Ribble Valley Borough Council
Housing & Development Control

Application no: **3/2023/0956**

Address: **Ravenscourt Neville Street Longridge PR3 3FD**

Proposal: **Demolition of existing dwelling, outbuildings and detached garage and erection of four single-storey dwellings.**

# PROPOSED SITE PLAN

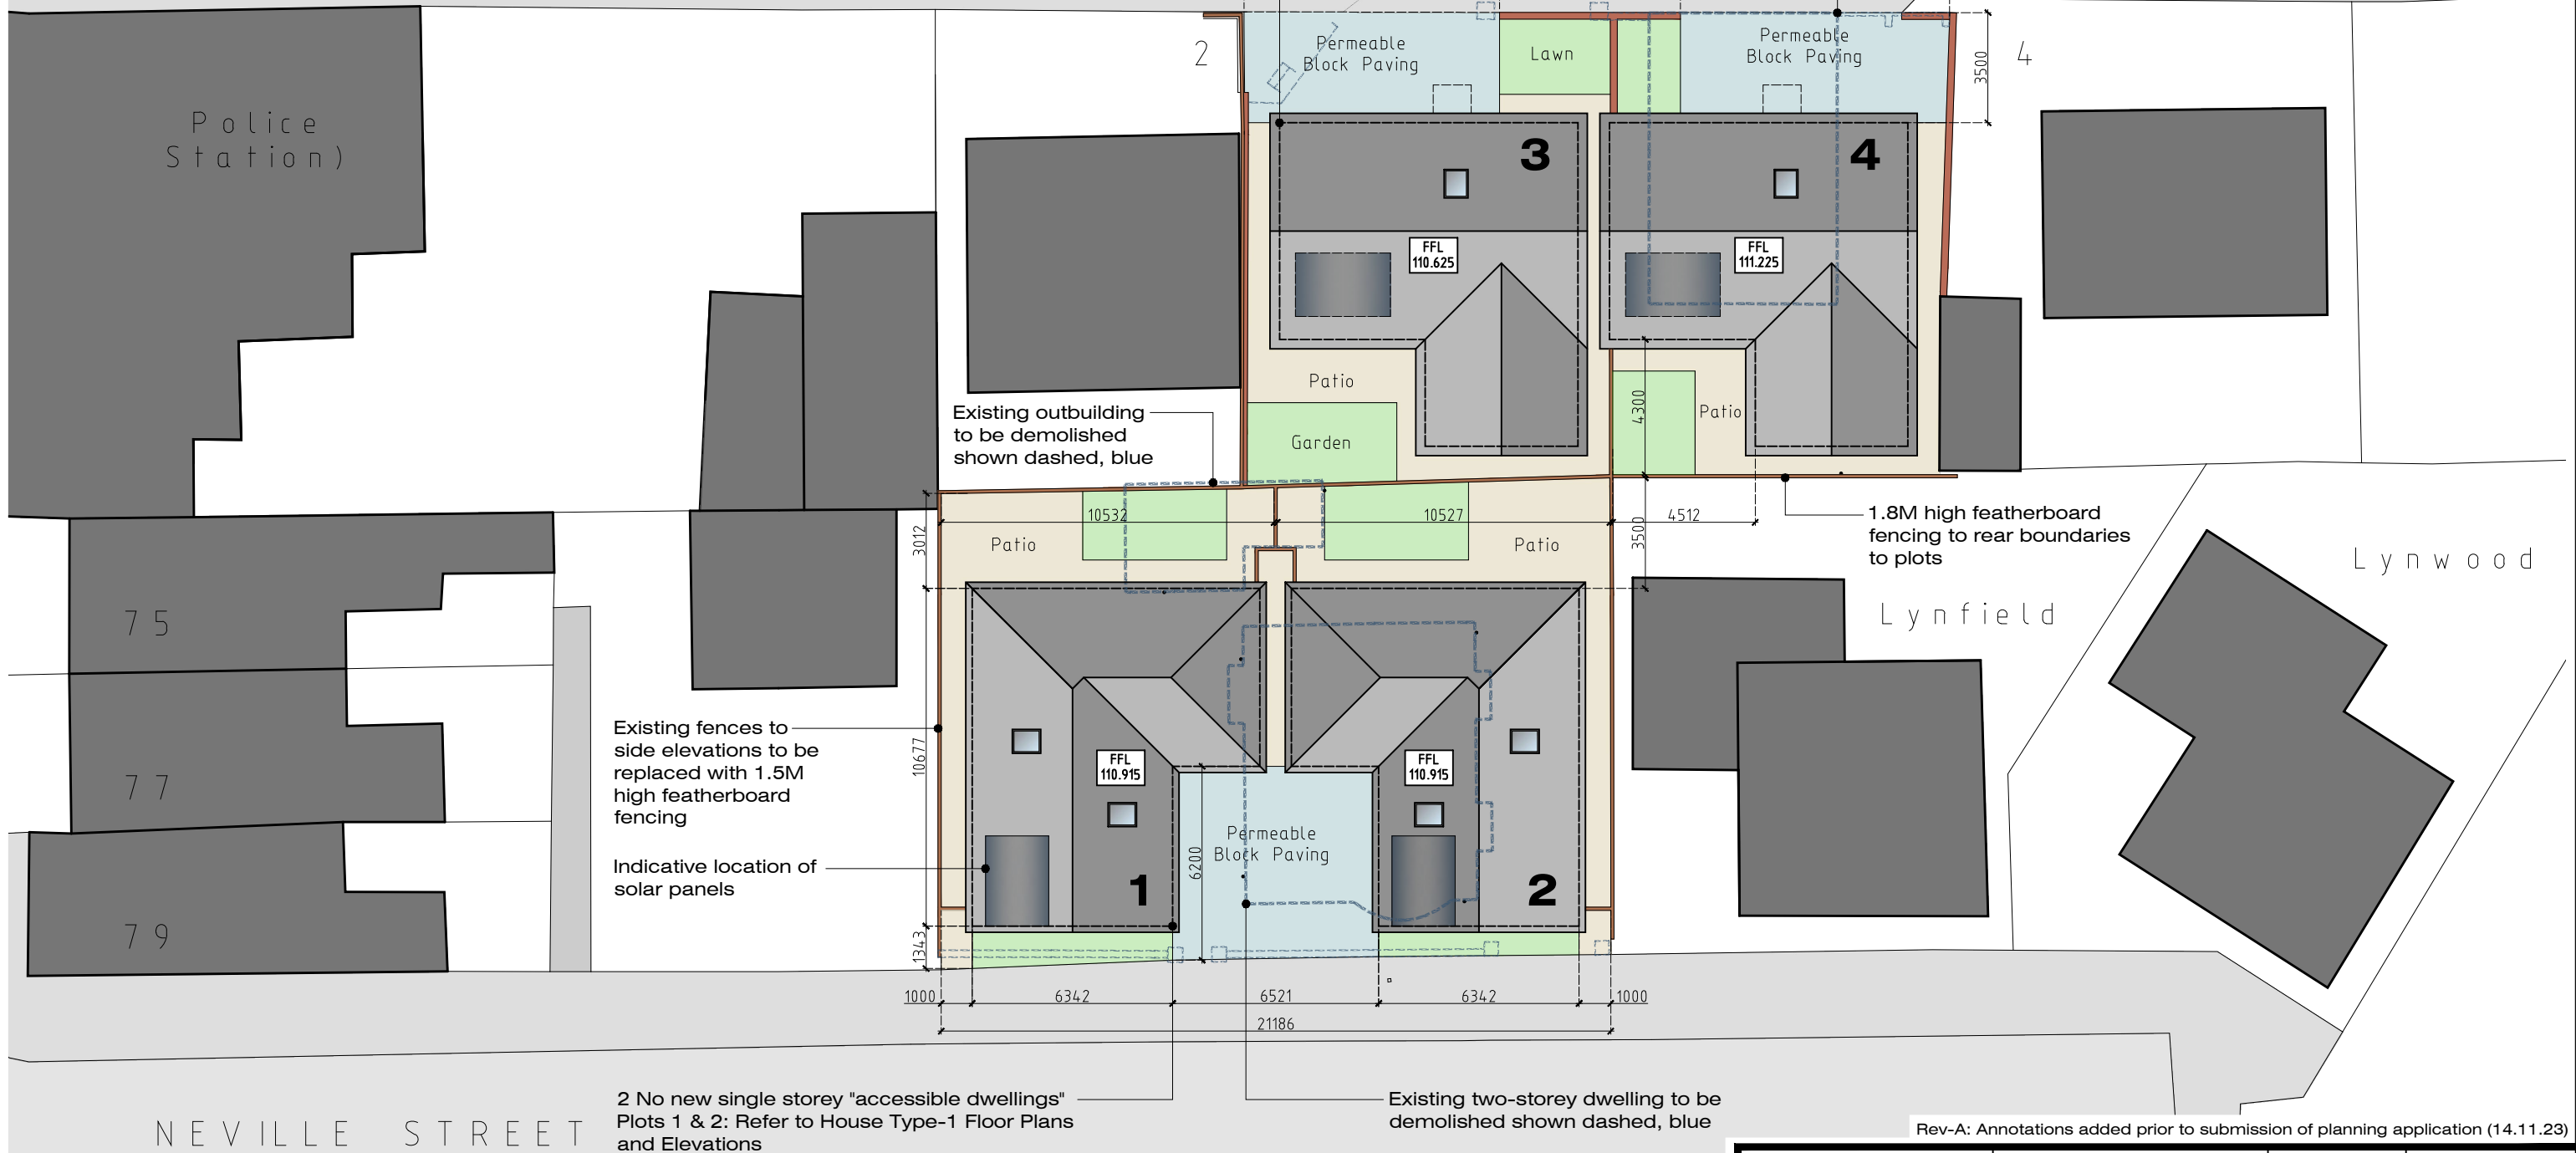
The LHA have reviewed Monks drawing number JM-0263-004 Rev A titled "Proposed Site Plan" and note that Plots 1 and 2 will be accessed from Neville Street, while Plots 3 and 4 will be accessed from Fleet Street. Both roads are unclassified and subject to a 20mph speed limit.

The Agent has stated that each Plot will have access to one bedroom. However, the LHA have reviewed the floor plans and deem that the dwellings will have access to two bedrooms with each dwelling having a snug room. Therefore, for the site to comply with the LHAs parking guidance as defined within the Joint Lancashire Structure Plan, the LHA require each dwelling to have access to 2 car parking spaces each.

Despite this, the Agent has only provided each dwelling with one car parking space each. Even then the LHA are unable to accept the parking for Plots 3 and 4 with the proposed driveways not having the adequate depth to provide a car parking space. With the LHA requiring a driveway to be a minimum of 4.8m long to comply with the LHAs guidance. Therefore, the Plots along Fleet Street have a shortfall of 4 spaces and the Plots along Neville Street, a shortfall of 2.

The LHA also require a Section 278 agreement to be reached between the LHA and the Developer. An agreement is required following the creation of an access to serve Plots 1 and 2 at Neville Street and to stop up any redundant dropped crossings to full height kerbs along Fleet Street and Neville Street which relates to the existing site.

Notwithstanding this, the LHA will accept the shortfall in parking. This is because the site is located in a sustainable location within walking distance of Longridge town centre where key local amenities are found. The site is also in close proximity to two bus stops located along Derby Road. These bus stop serve services to Blackburn, Preston and Longridge at hourly intervals throughout the day.

Should occupants need an area to park, there is ample on-street capacity for occupants to park without posing a highway safety concern. Therefore, it would be unreasonable for the LHA to object due to the lack of parking at the site.

However, to support sustainable transport the LHA will condition that each dwelling has access to a cycle storage facility and Plot 1 and 2 have access to an electric vehicle charging point.

2. No part of the development hereby approved shall commence until a scheme for the construction of the site access and the off-site works have been submitted and approved by the Local Planning Authority. The works shall include the following and be completed prior to occupation.

- Reinstating redundant dropped kerbs along Neville Street and Fleet Street.
- Dropped crossing at Neville Street.
